**Consultation Response from KC,  
Highways Development Management****2023/92103 Dixon Hall And Co Ltd, Grafton Street, Batley, WF17 6AR****Prior notification for change of use from offices to 6 dwellings****Date Responded: 21-8-2023.****Responding Officer: Mark Berry****Responding Ref: 15-4SE-14.**

Prior notification for change of use from offices to 6 one bedroomed apartments at Dixon Hall and Co Ltd, Grafton Street, Batley.

3 Proposed Site Plan
1:200

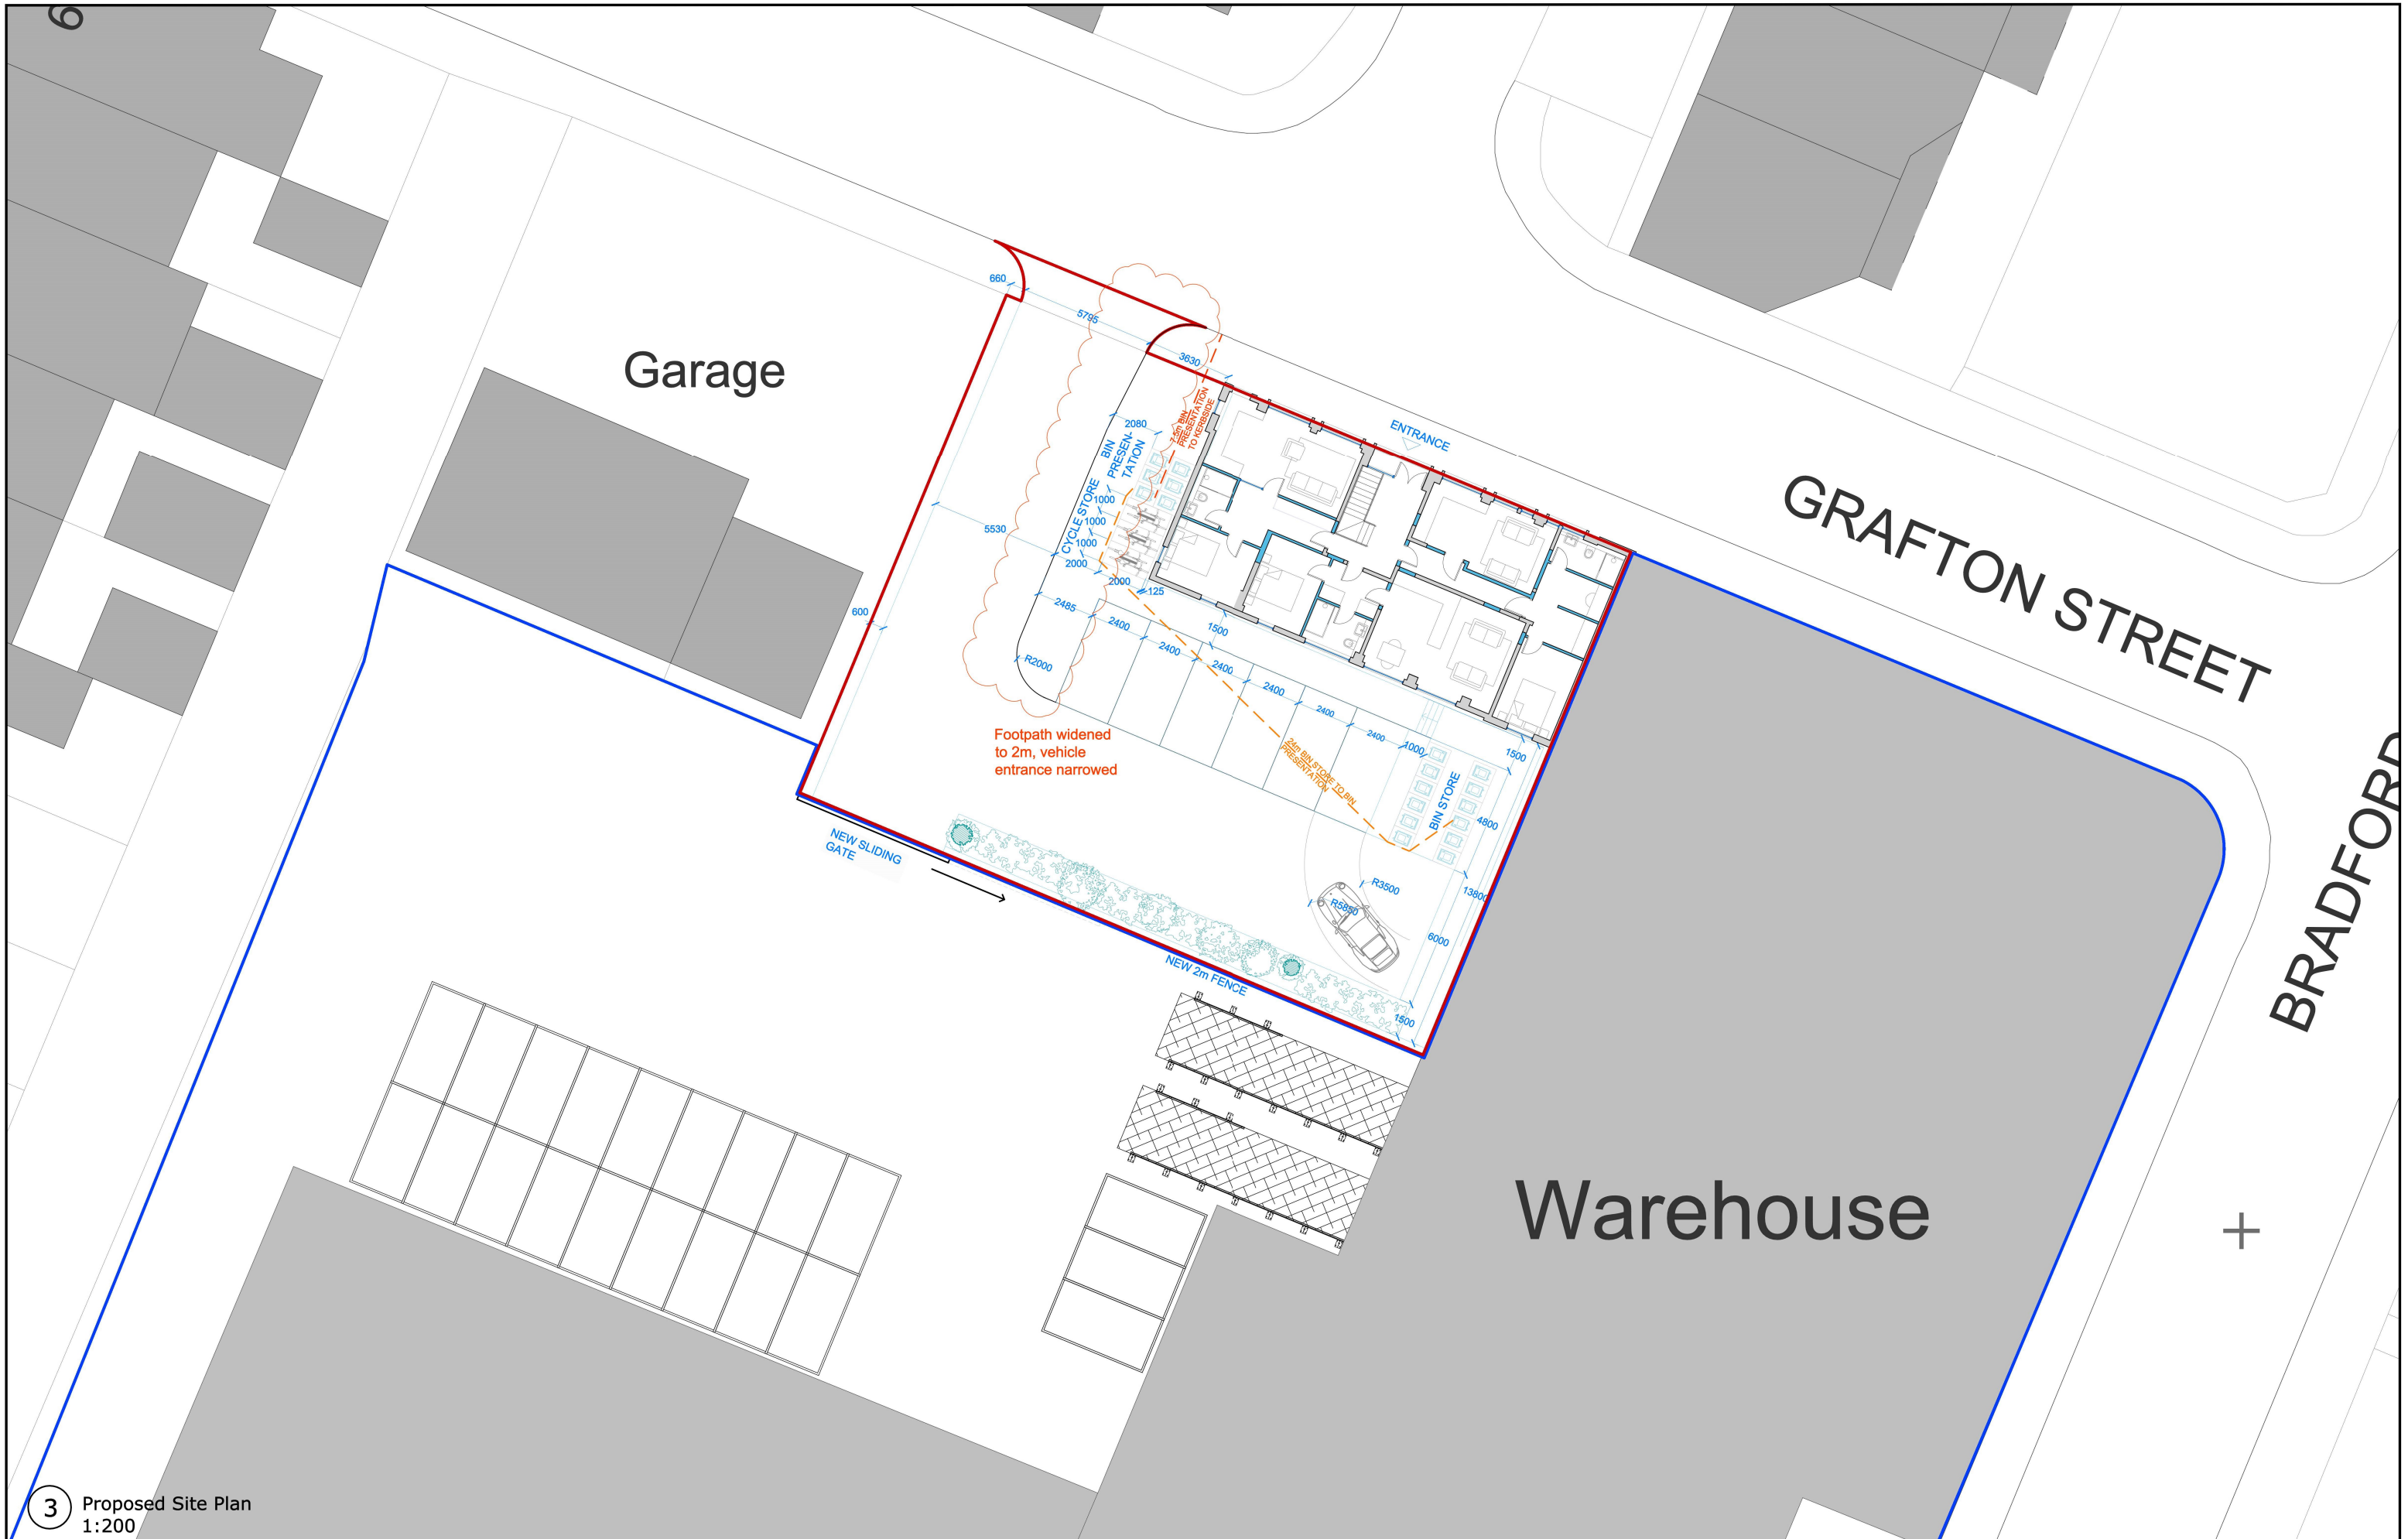
The Proposed Site Plan number 2120-LP02 rev A shows a short length of 6.0m wide access road with 1.5m wide footway to the eastern side and 0.6m hard margin to the western side leading through to the remaining part of the 'Dixon Hall Tools' industrial site. Access to the remaining site is shown via a new sliding gate through a new 2.0m high fence which separates the proposed residential development.

This application provides insufficient information.

1, A 2.0m wide footway should be provided to the eastern side of the proposed access road.

2, The applicants should demonstrate that the loss of off-street parking and service yard to residential use still allows sufficient space for HGV access and internal vehicle turning and that that sufficient off-street parking is retained to the remaining 'Dixon Hall Tools' industrial site.

3, The applicants should demonstrate that good visibility is provided between vehicles exiting the proposed parking area and vehicles exiting the access to the remainder of the 'Dixon Hall Tools' industrial site via the sliding gate.
